City of Portland, Maine - Building or Use Permit Application
 389 Congress Street, 04101 Tel: (207) 874-8703, Fax: (207) 874-8716

Permit No: 05-0029	Issue Date:	CBL: 388 B038001
------------------------------	--------------------	----------------------------

Location of Construction: 31 Longview Dr Lot # 8	Owner Name: Chuck Place	Owner Address: 31 Longview Dr	Phone:
Business Name:	Contractor Name: Jim Lombardo	Contractor Address: 69 Milton St Portland	Phone 2073295484
Lessee/Buyer's Name	Phone:	Permit Type: Single Family	Zone:

Past Use: Vacant Lot	Proposed Use: Single Family Home 2000 sq ft home -w /attached Garage	Permit Fee: \$1,176.00	Cost of Work: \$120,000.00	CEO District:
Proposed Project Description: Single Family Home 2000 sq ft home -w /attached Garage		FIRE DEPT: <input type="checkbox"/> Approved <input type="checkbox"/> Denied	INSPECTION: Use Group: Type	
		Signature:	Signature:	
PEDESTRIAN ACTIVITIES DISTRICT (P.A.D.)				
Action: <input type="checkbox"/> Approved <input type="checkbox"/> Approved w/Condition <input type="checkbox"/> Denied				
Signature: Date:

LEFT ELEVATION

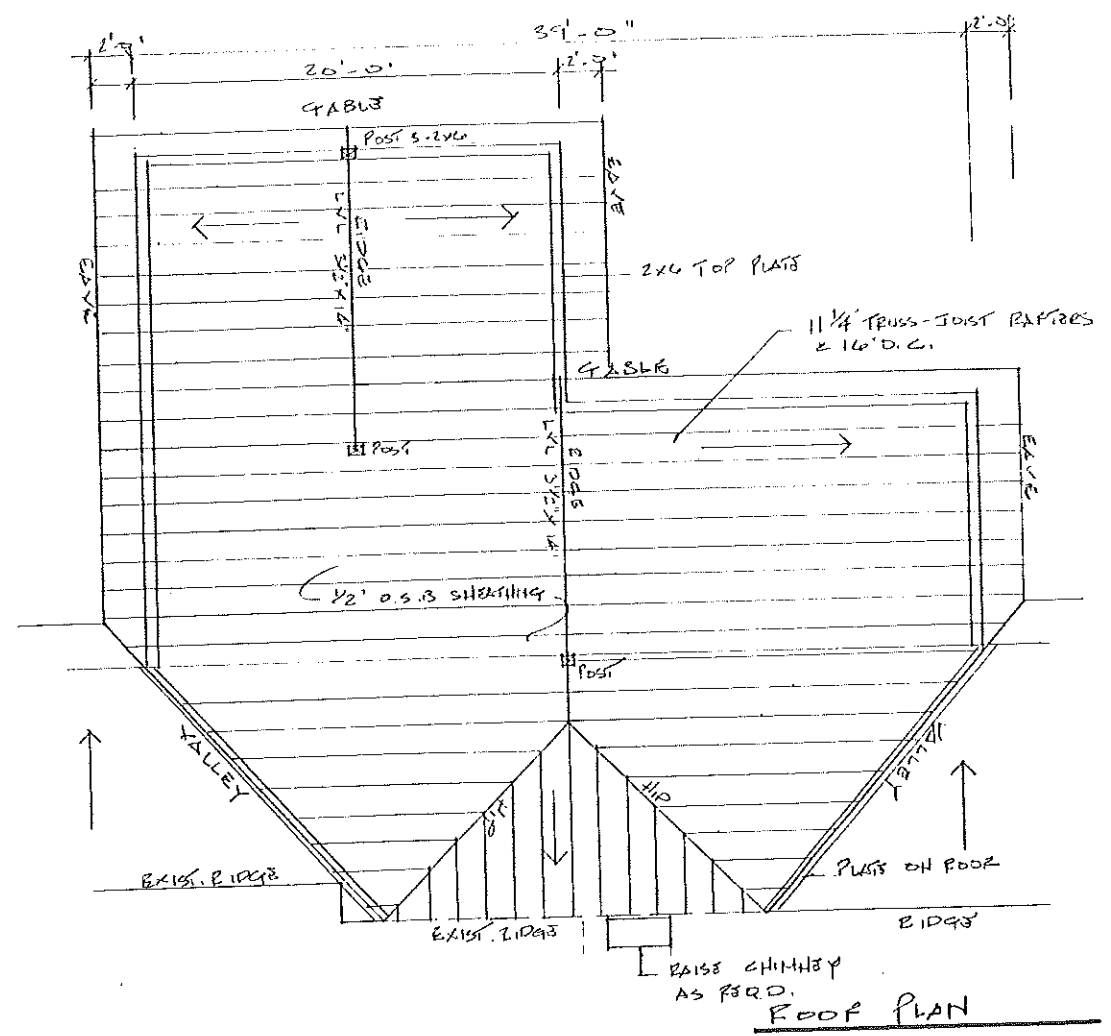
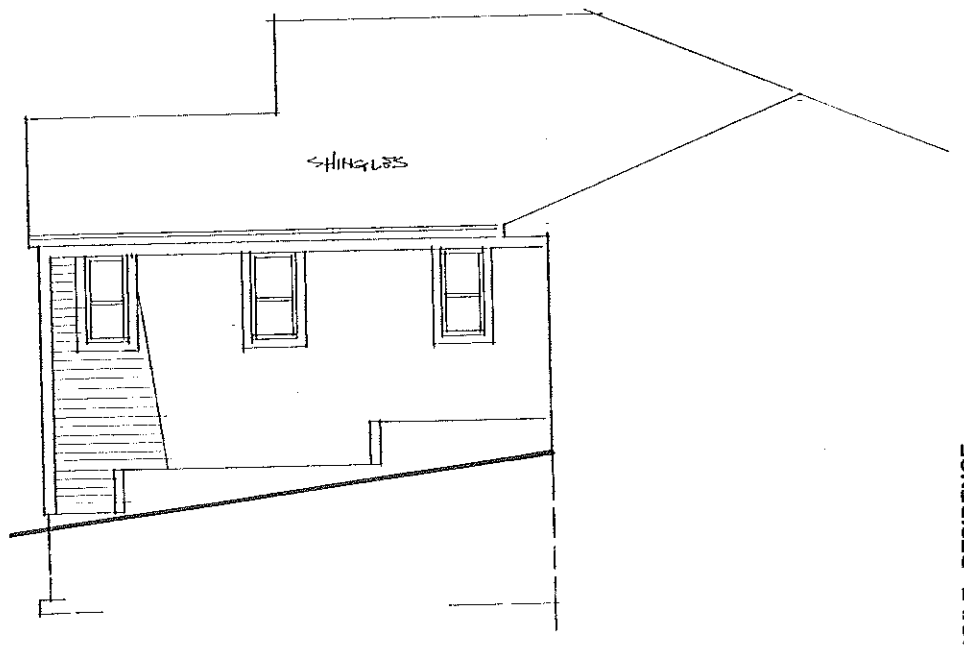
- 1) The basement is NOT approved as habitable space. A code compliant 2nd means of egress must be installed in order to change the use of this space.
- 2) The design load spec sheets for any engineered beam(s) must be submitted to this office.
- 3) A copy of the enclosed chimney disclosure must be submitted to this office upon completion of the permitted work or for the Certificate of Occupancy.
- 4) Permit approved based on the plans submitted and reviewed w/owner/contractor, with additional information as agreed on and as noted on plans.
- 5) Separate permits are required for any electrical, plumbing, or heating.
- 6) Application approval based upon information provided by applicant. Any deviation from approved plans requires separate review and approval prior to work.

PLOT PLAN

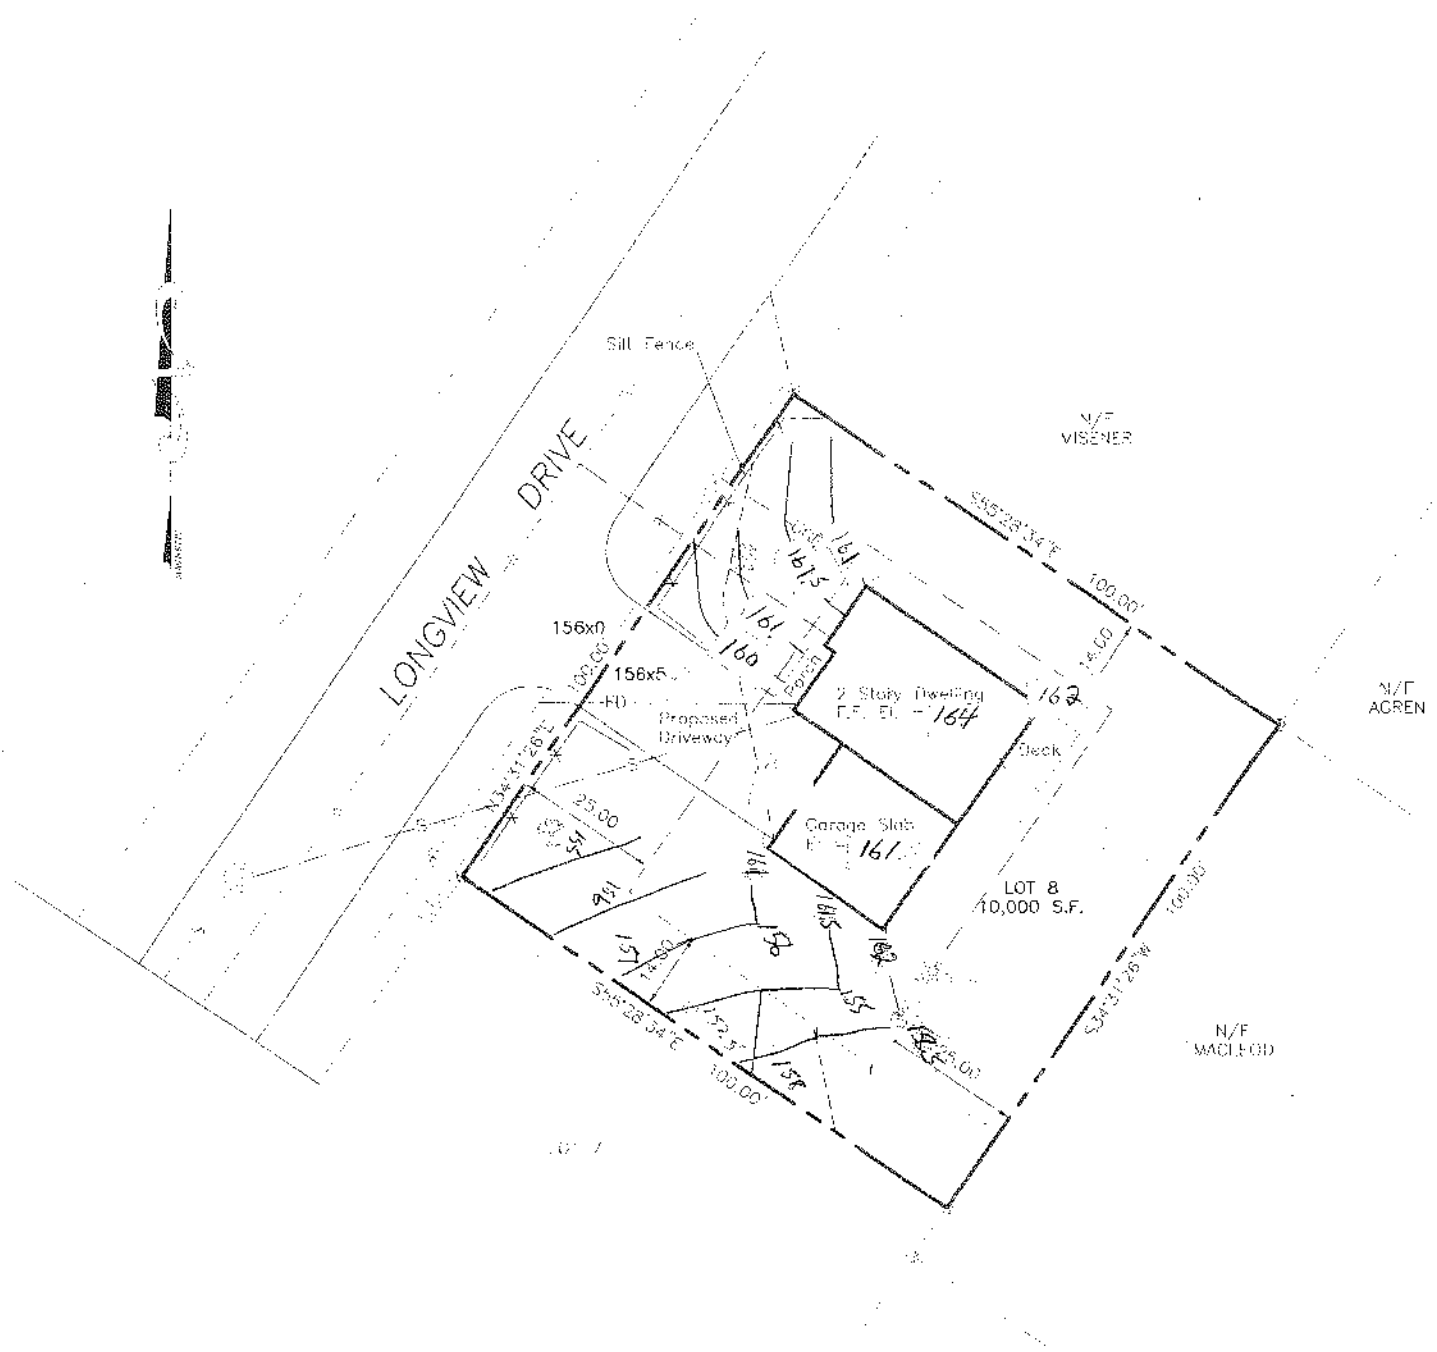
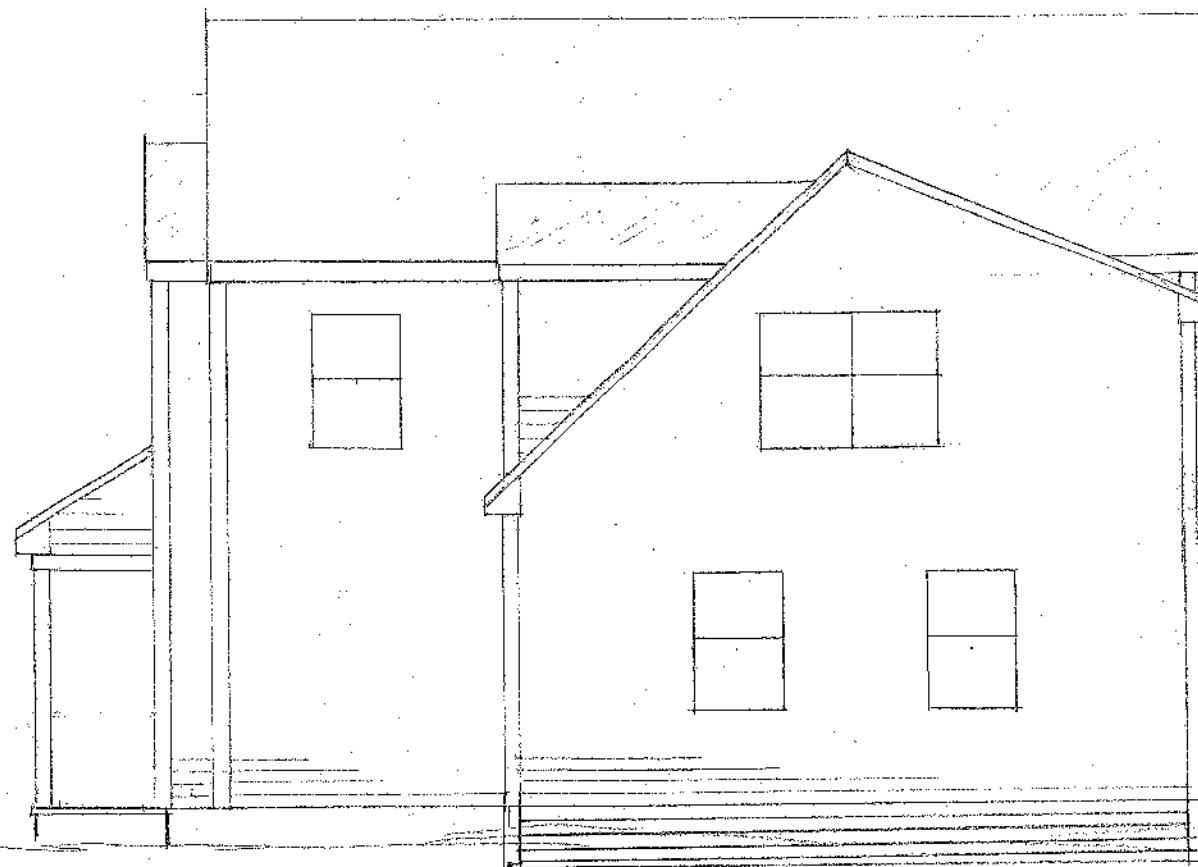
- 1) NO DAYLIGHT BASEMENT is being shown. NO DAYLIGHT BASEMENT is being approved.
- 2) Separate permits shall be required for future decks, sheds, pools, and/or garages. Currently an 8'x12' rear deck is being shown along with a 4' x 12' front porch. Both rear deck and front porch are being approved with this permit.
- 3) This property shall remain a single family dwelling. Any change of use shall require a separate permit application for review and approval.
- 4) This permit is being approved on the basis of plans submitted. Any deviations shall require a separate approval before starting that work.
